Re: Planning Proposals for 31 Sea Way, Middleton on Sea
Ref: M/56/15/HH

This letter is One of **Objection** to the proposals not in relation to No. 33 particularly but in relation to the overall development of Middleton on Sea. The Objection is for the following reasons:

**REAR ELEVATION**  
(South) 1 . 1 0 0

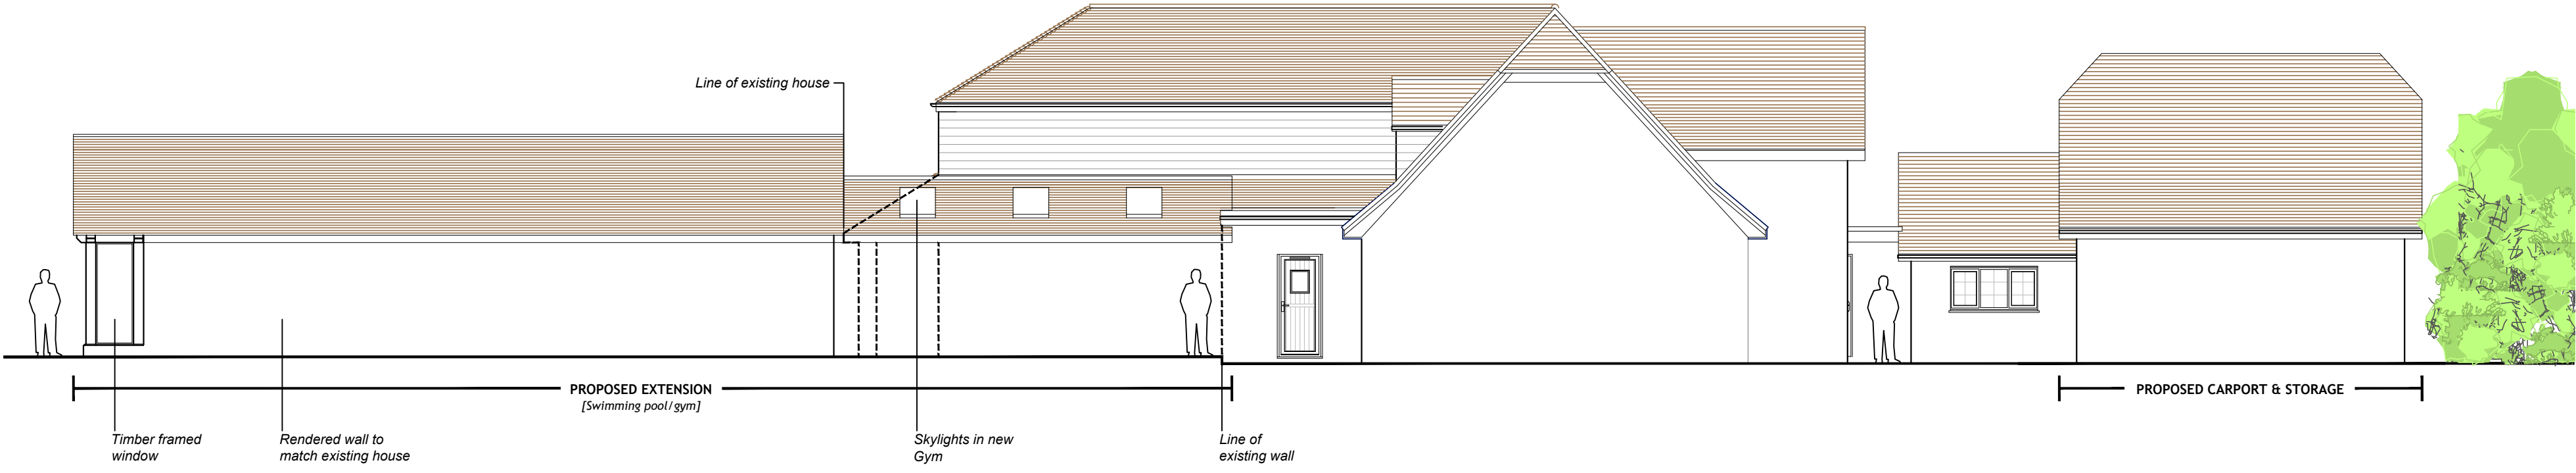
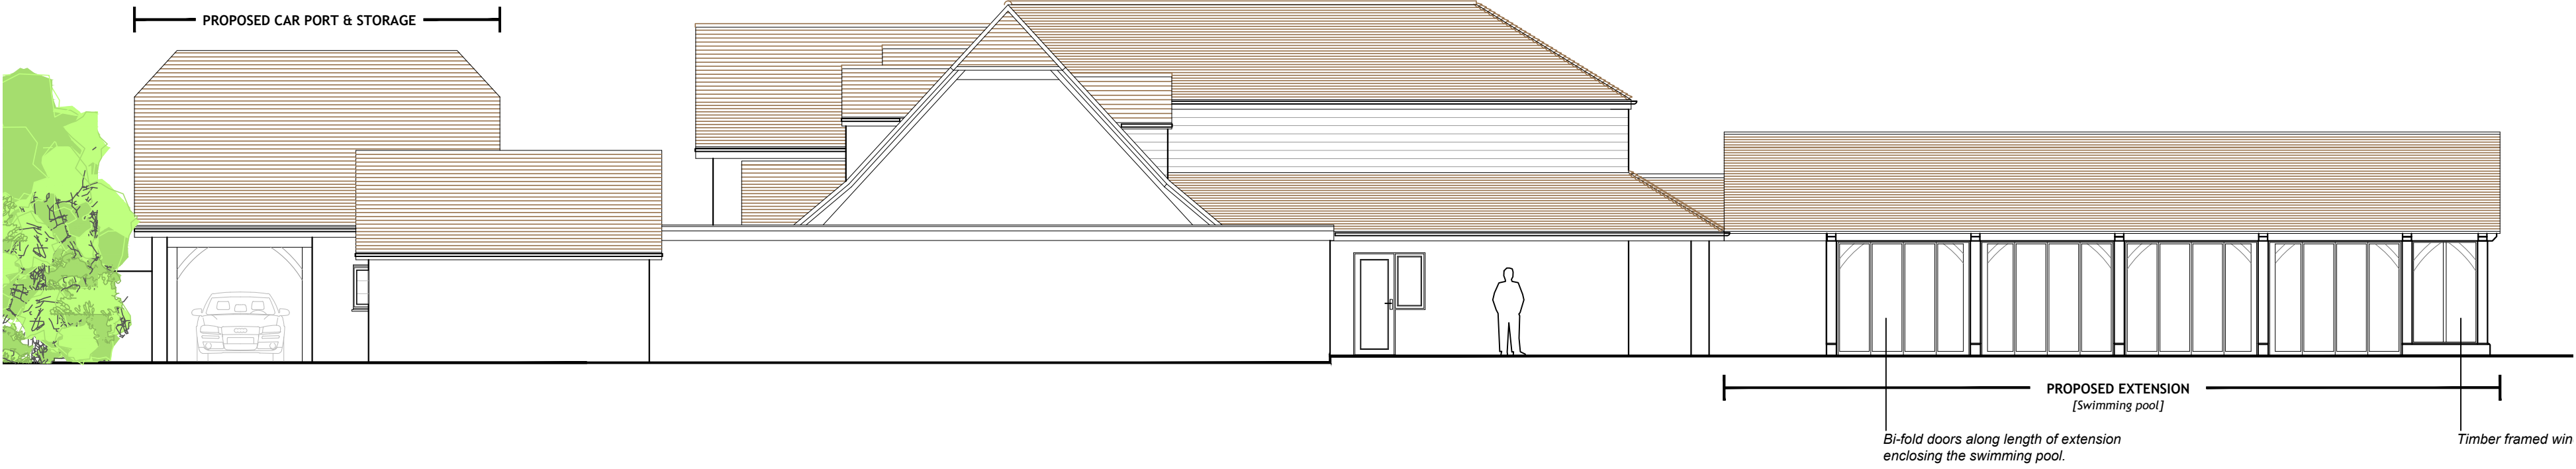
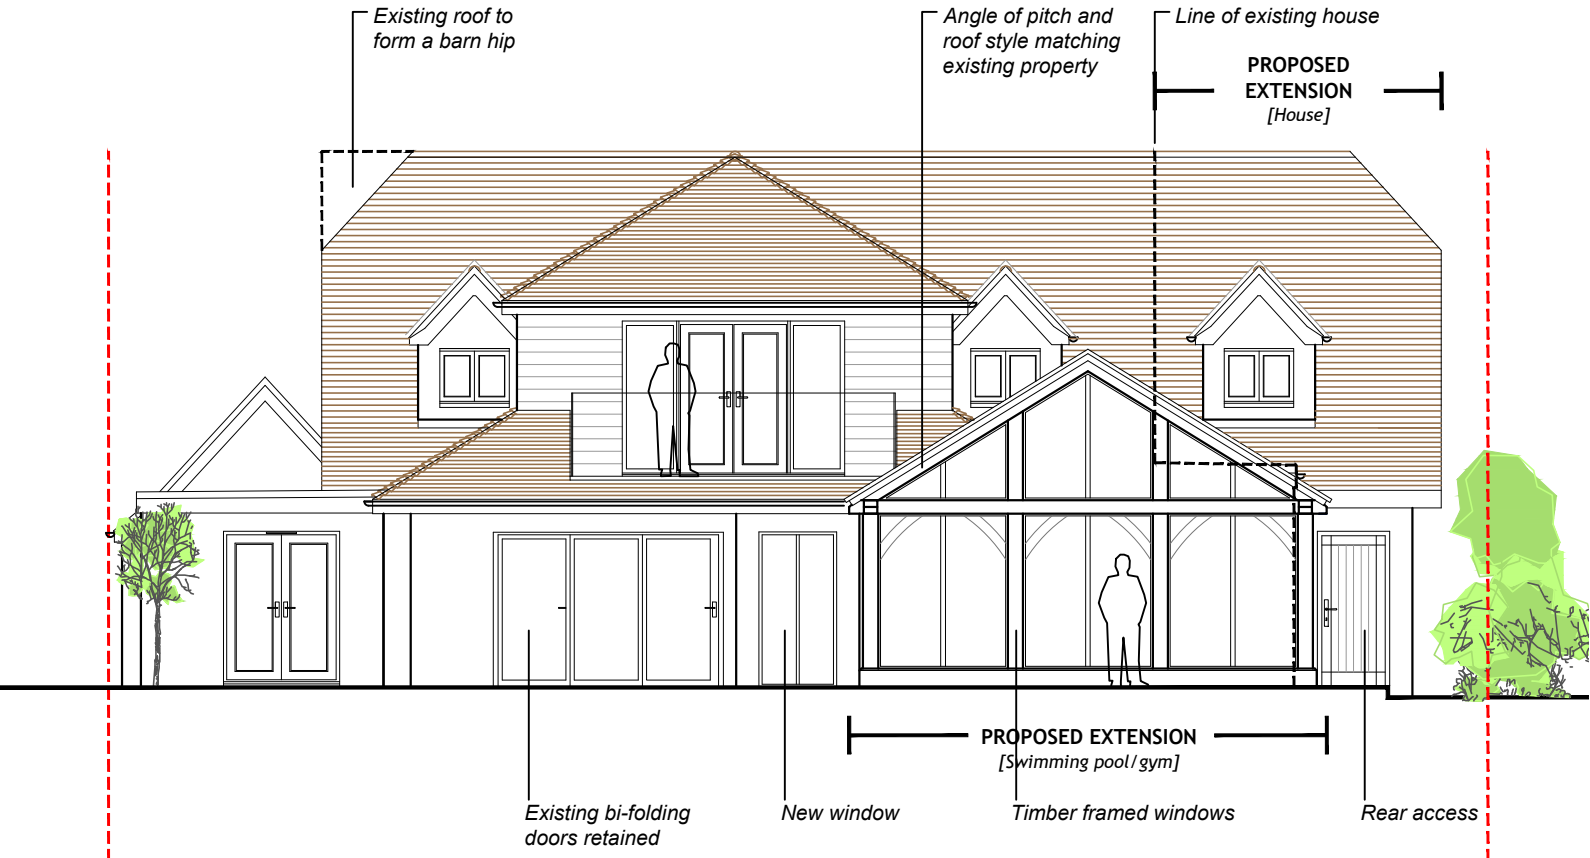
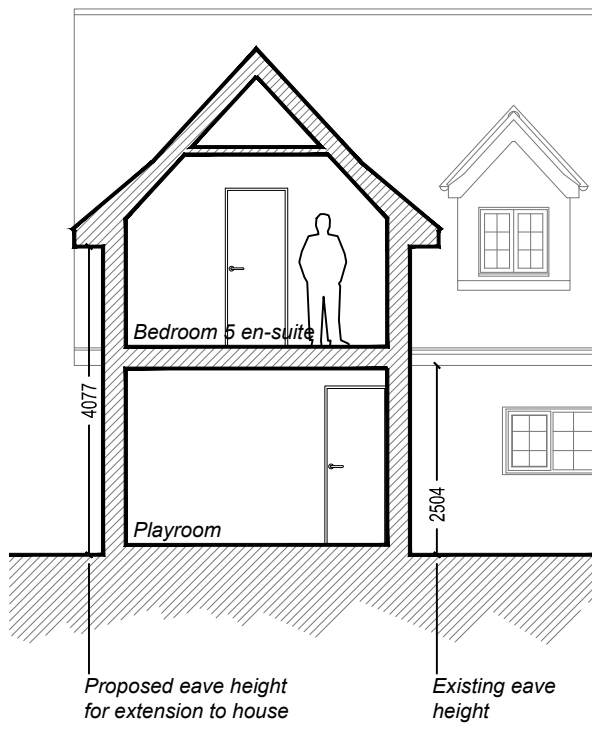
3. The proposal for the Southern extension over the swimming pool will extend well beyond No. 29 to the East.
4. The projection of the building and, in particular the high roof to the South will be to the detriment visually of all the Southern elevations and, in addition, will restrict the open visibility currently enjoyed by all Owners of properties in the immediate area.

**SECTION D-D**  
(Looking east) 1 . 1 0 0

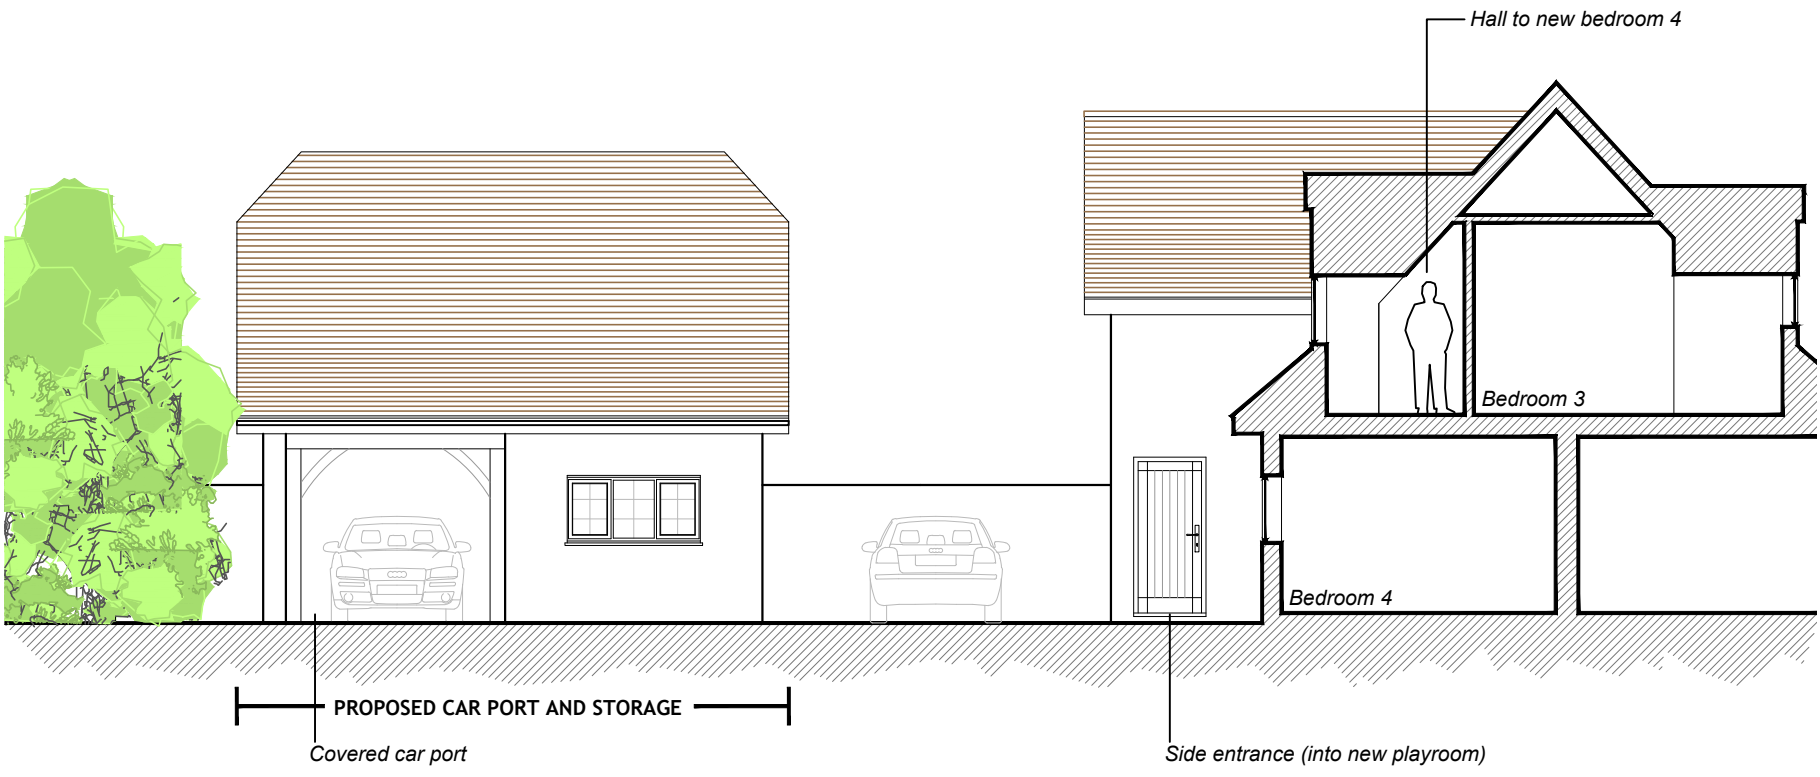
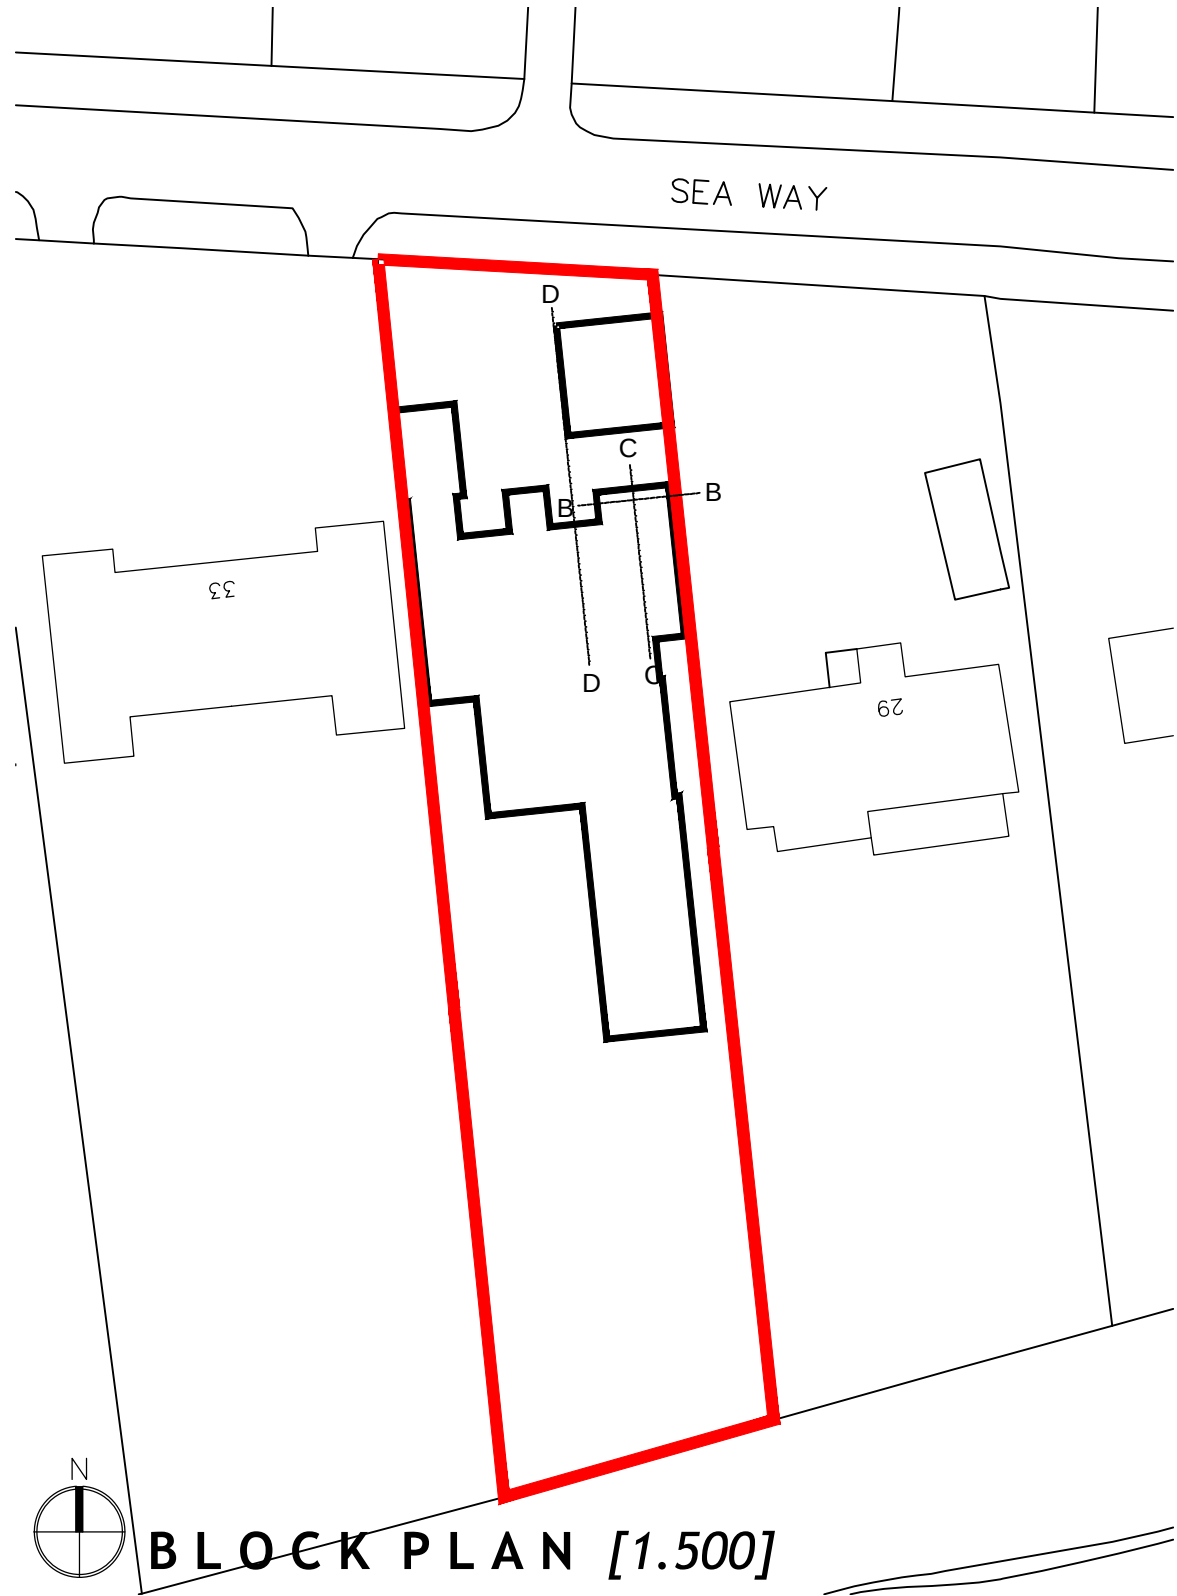
5. The proposed Garage and Storeroom building is detached from the main structure and accepting that these Garages exist in some adjacent properties, they are all single storey and the height of the roof is unacceptable and the space within the first floor is not designated and only appears on the section drawing.
